**Consultation Response from Mike Hibbert,  
KC Waste Strategy( Refuse & Recycling)**

**2024/90291 2, 4 & 6, Thornton Lodge Road, Thornton Lodge, Huddersfield, HD1 3JQ**

**Discharge of conditions 4. (bin storage/collection) & 5. (noise assessment) on previous permission no. 2023/92737 for Prior notification for change of use from shop/restaurant to three dwellings**

**Responding Ref: WPS 24-008**

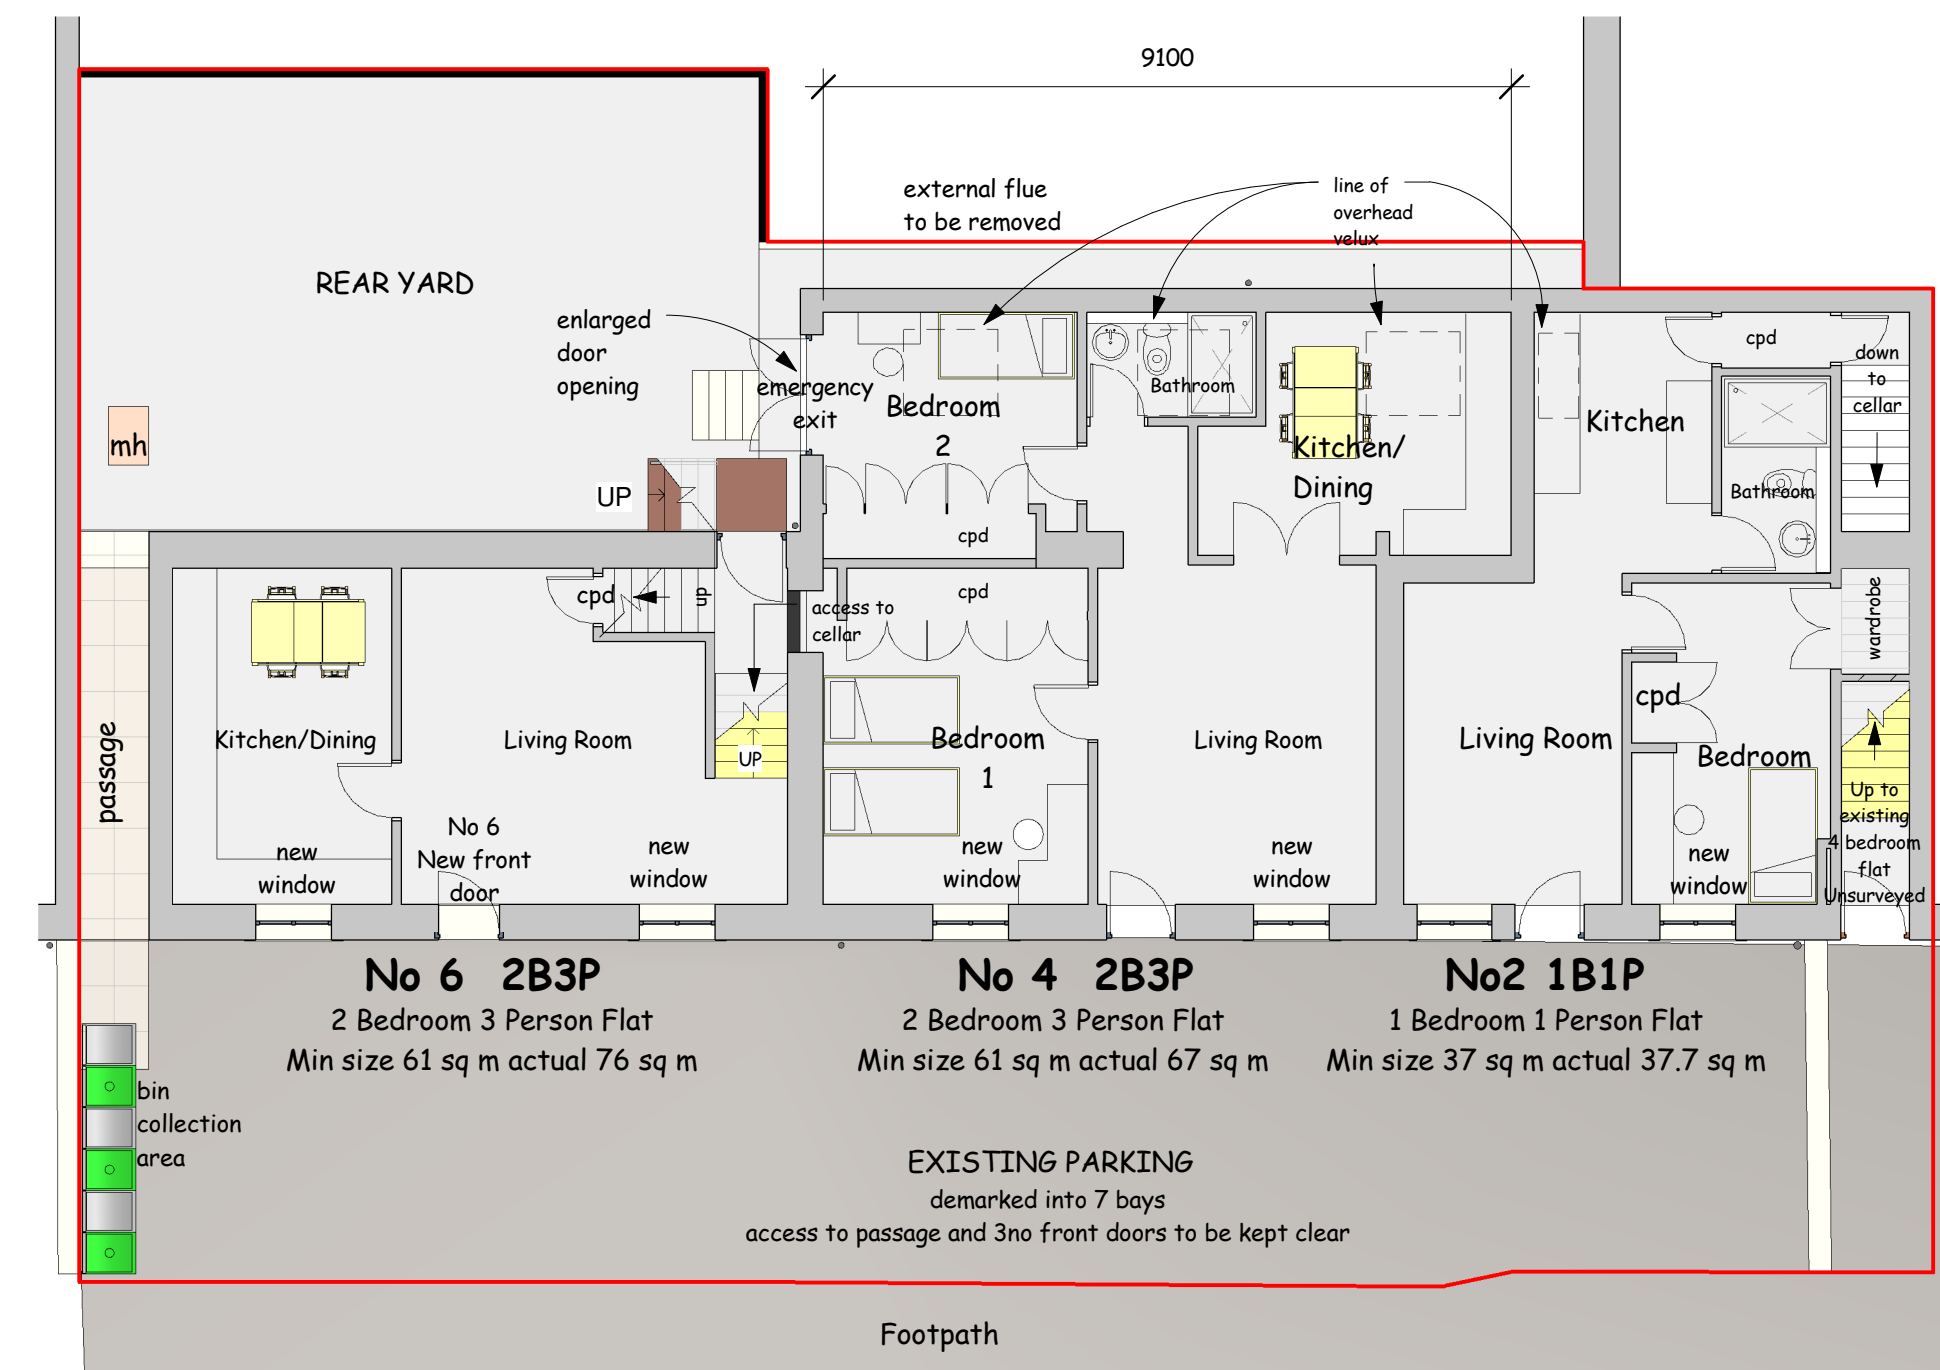
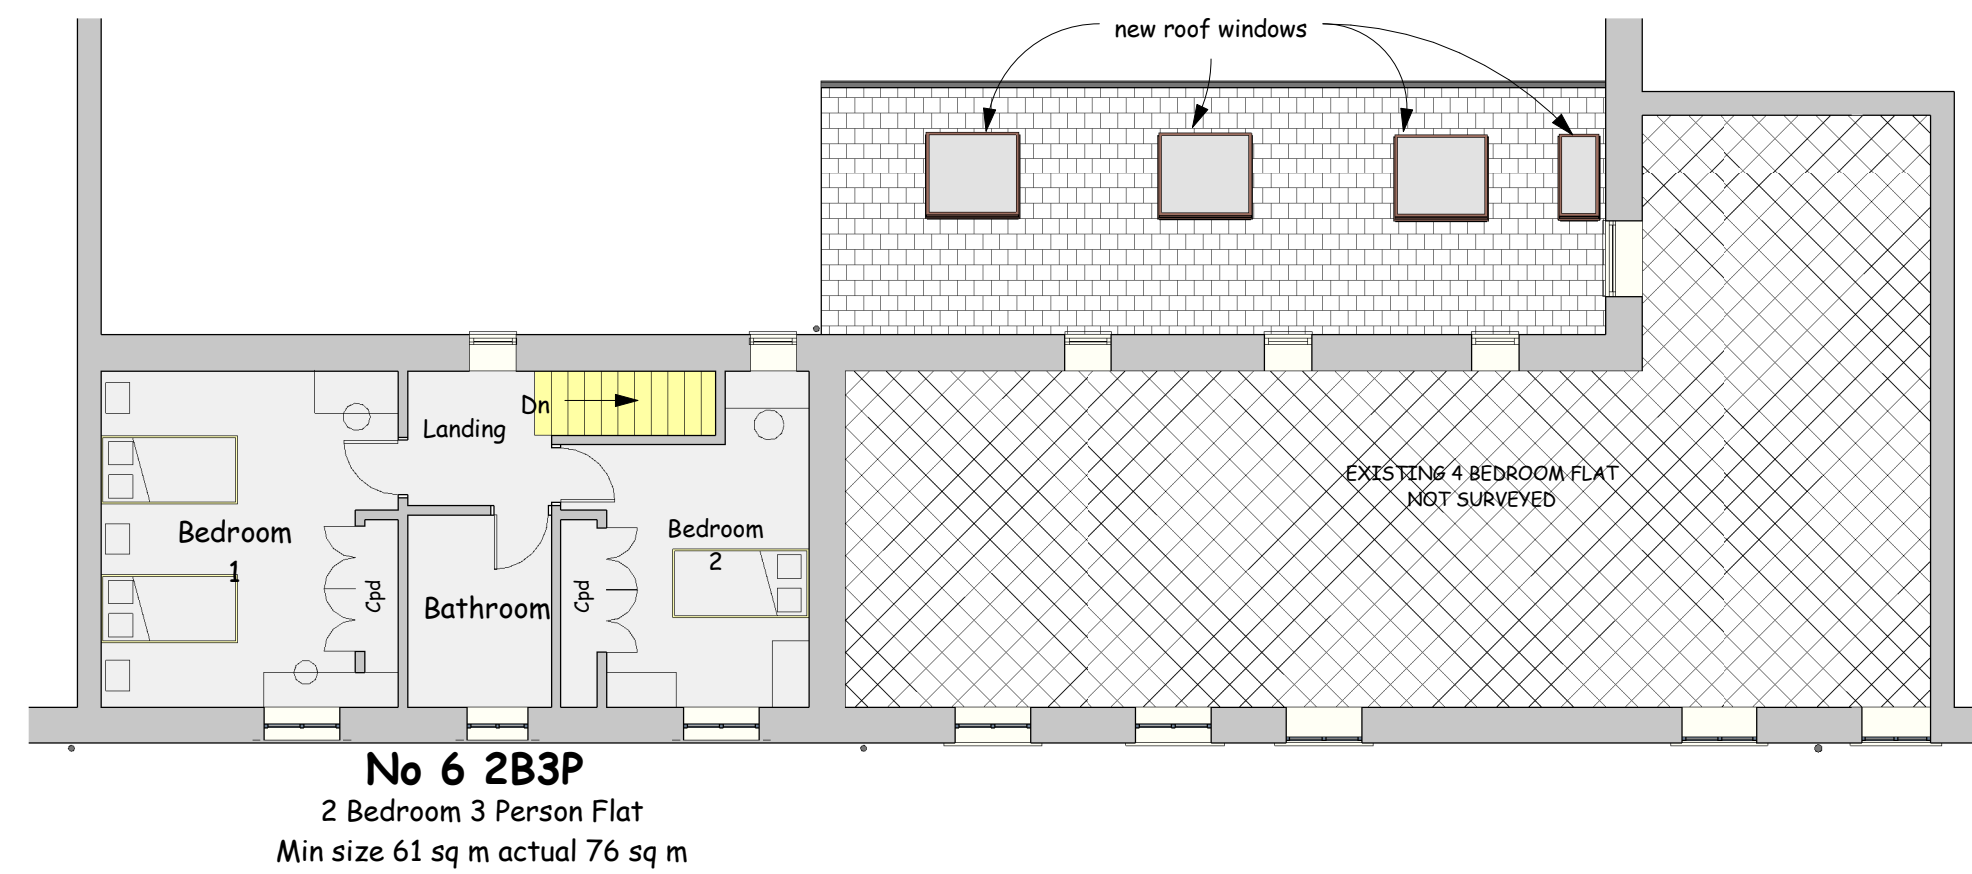
The applicant has submitted Plans, Elevations and Views as Proposed 2304 - 02 Rev A Dated 17/01/2024. This shows a Bin Collection area for six wheeliebins on the hard standing area fronting Thornton Lodge Road.

This location is appropriate as a bin collection point but permanent storage of bins at this position without a permanent screened bin store would be inappropriate due to impact on Streetscene and potential theft, arson or fly tipping.

The passageway through to the rear yard is approximately 870mm wide that should be large enough to enable passage of a standard 240 ltrs wheelibin.

On this basis storage of bins in the rear yard, if not immediately adjacent to windows or doors,would be more appropriate with drag out of bins by residents on collection day to the bin presentation point at the front of the properties.

If rear storage and presentation at the bin collection area at the front is implemented the WCA does not have an objection to discharge of condition 4.
